**POWERHOUSE PARRAMATTA RESPONSE TO FURTHER SUBMISSIONS – MOD 1 TO STATE
SIGNIFICANT DEVELOPMENT CONSENT SSD-10416 – ST GEORGE'S TERRACE**

I refer to your request for heritage advice in relation to submissions made by the City of Parramatta Council (the Council) for the Section 4.55(1A) Modification Application (MOD 1) to the Powerhouse Parramatta project (SSD-10416) with regard to St George's Terrace.

DRAWING NUMBER	REVISION
A-993011	1

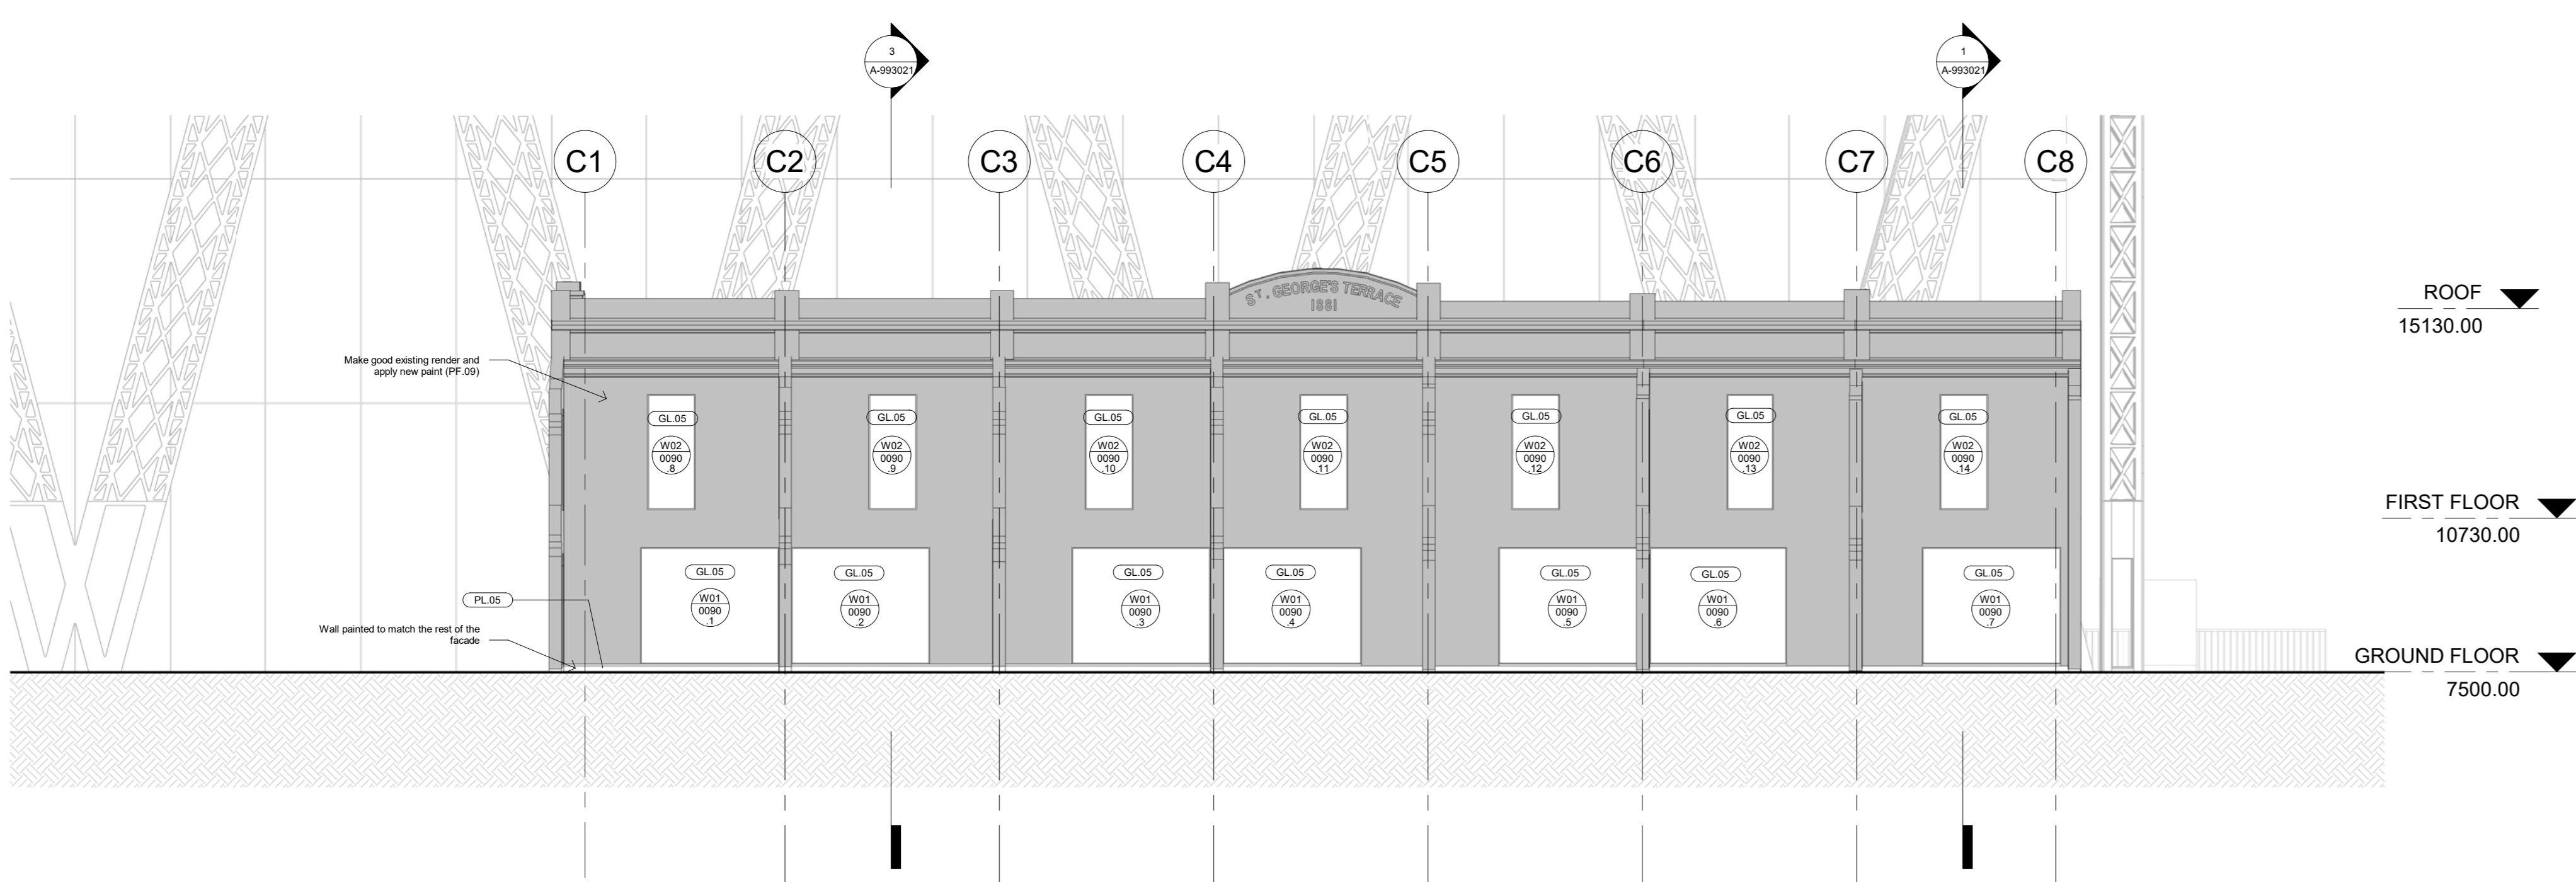
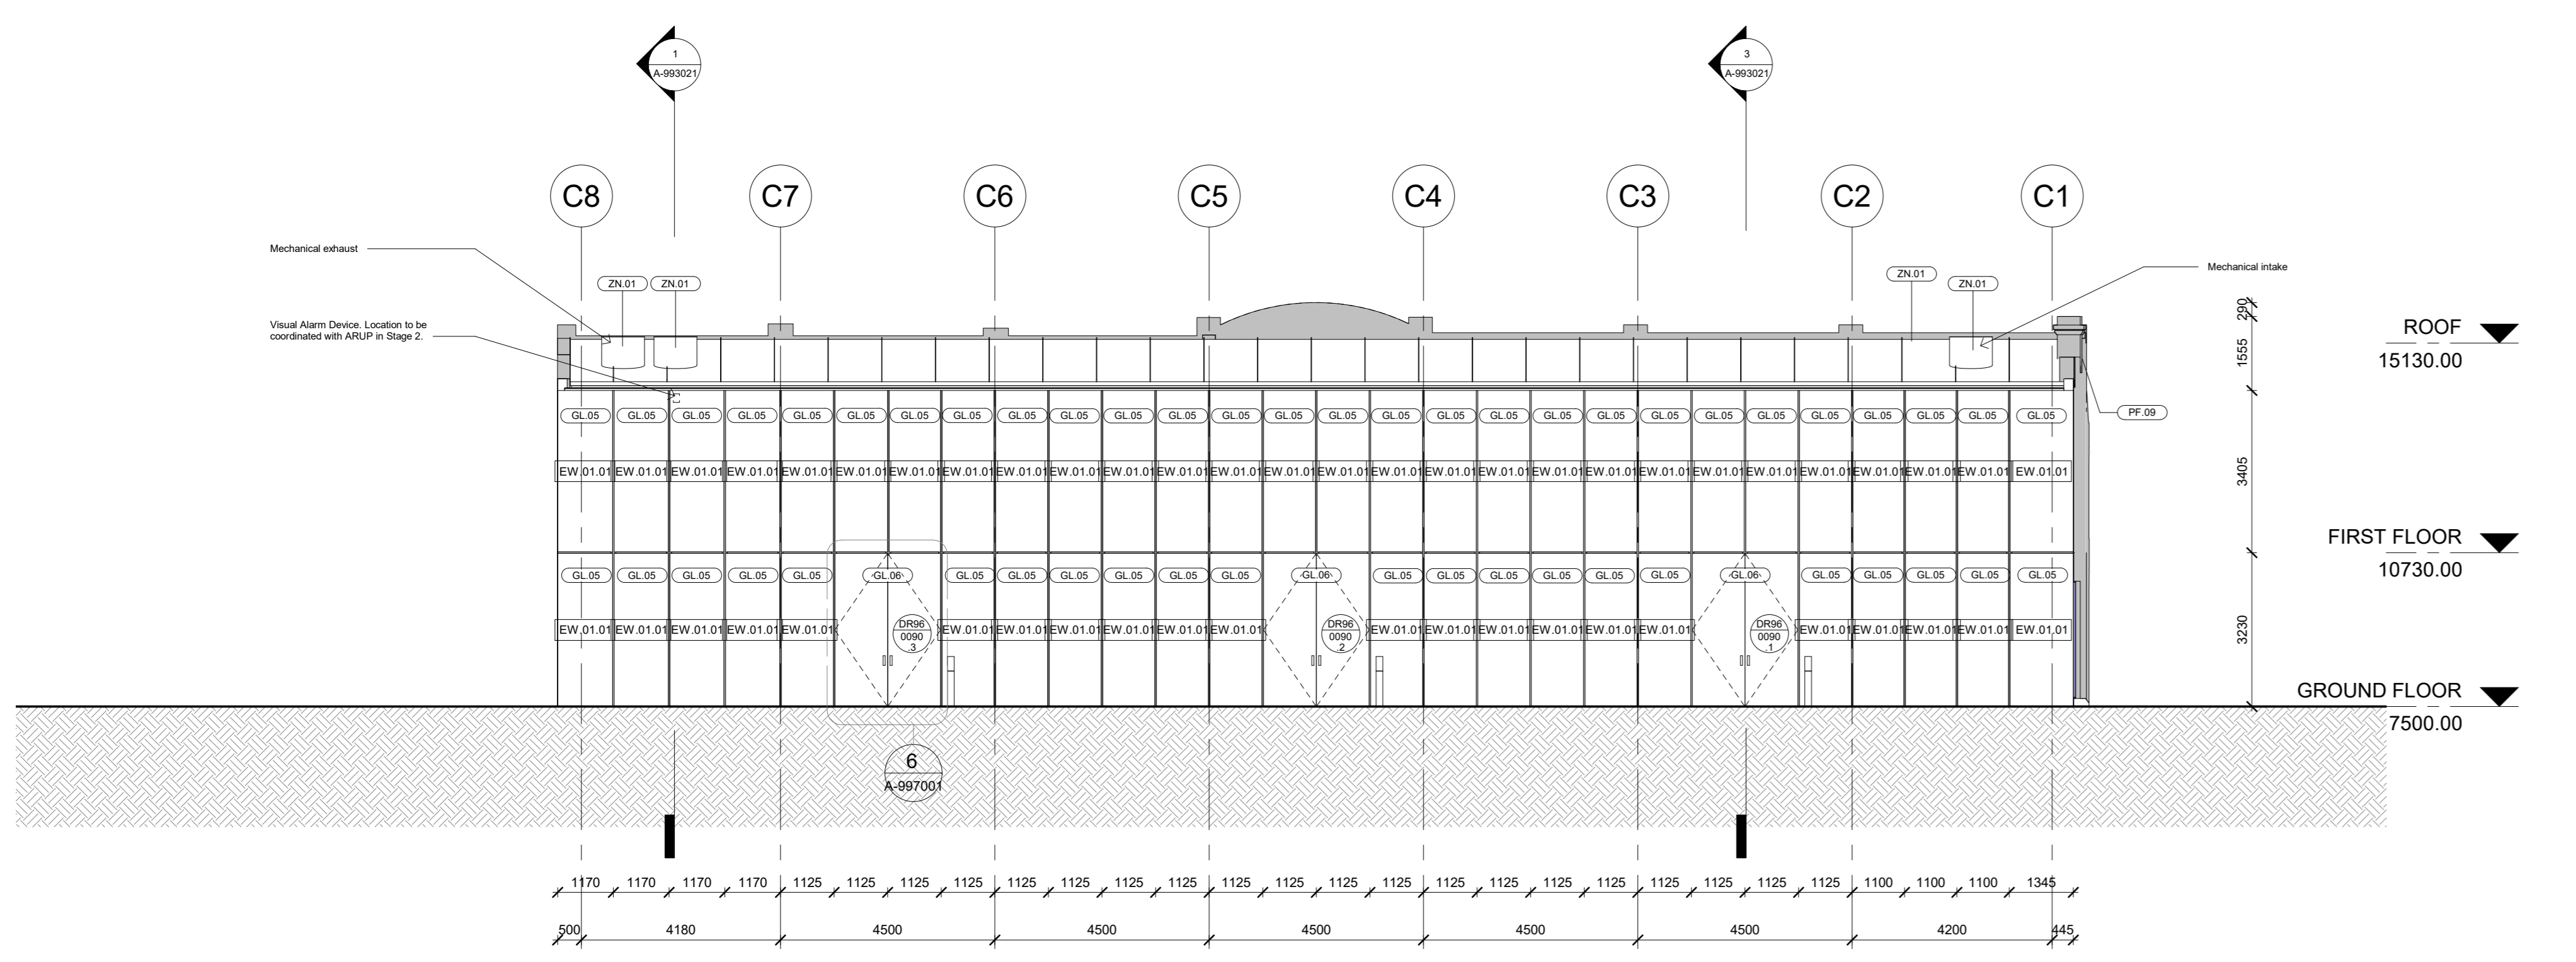
Advisian understands that the Council has recommended the reinstatement and restoration of the first-floor verandahs to St Georges Terrace (reference No. COPC18 and COPC28). Council's response of 15 July 2022 stated that:

"The balconies floor details and the upper balcony roofing are documented in manuals and similar example across Sydney. Unfortunately, no other example of a row of terraces with the same characteristic of St George terrace exist in Parramatta LGA. Therefore, this part of the facade is considered vital to Council to ensure the reinterpretation is authentic to the building's original fabric as a double storey terrace home and not a 1970's era shop façade.

The balconies are a distinctive characteristic of this typology and double storey terrace. It is strongly recommended that those would be reinstated using traditional materials with simple details if not evidences of the original are sourced."

20.2 <i>Reconstruction</i> should be identifiable on close inspection or through additional <i>interpretation</i> .	It is proposed that in lieu of an authentic reconstruction of the first-floor verandahs, an interpretive element would be installed to complement the remaining brick privacy walls with recessed arches that currently provide some physical evidence of the former verandahs and the residential terrace typology.
